Our reference: ECM: 7836789
Contact: Gavin Cherry
Telephone: 4732 8125

19 October 2017

Notice of Exhibition, St Marys Resource Recovery Facility at 21 and 25 Dunheved Circuit, St Marys (SSD 8200)

Figure 3.1: Proposal Site Layout

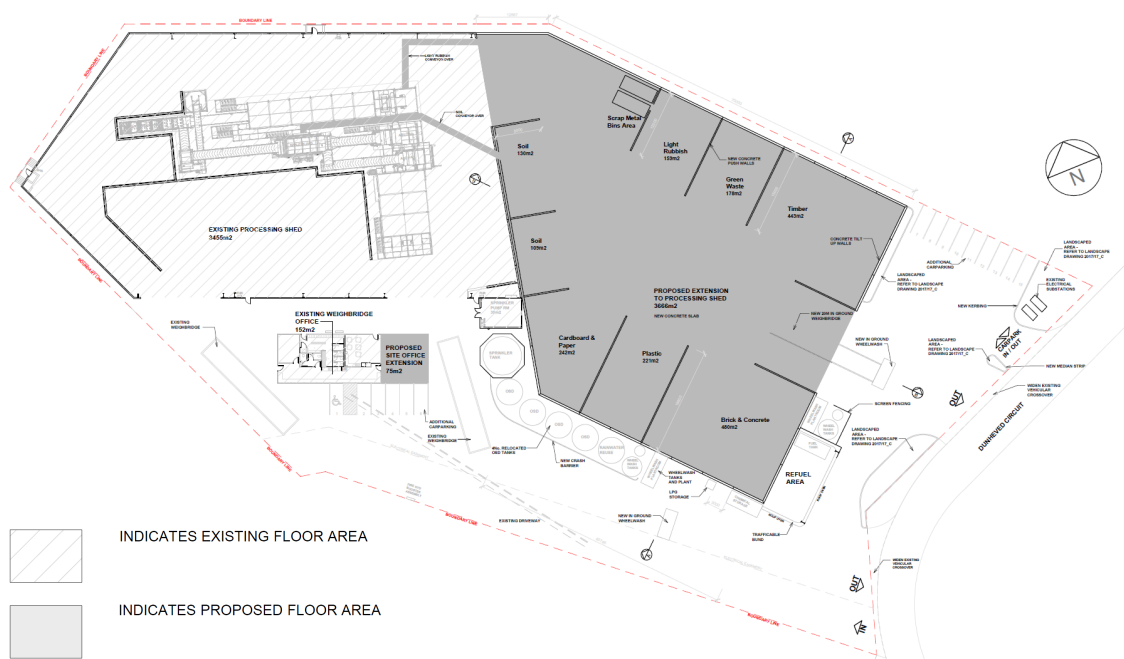
A detailed site plan should be prepared showing the location and maximum height(s) of stockpiled materials, including unexpected finds material. The Proposal Site Layout Plan included in the application does not detail stockpile heights nor nominate the location for the storage of unexpected finds.
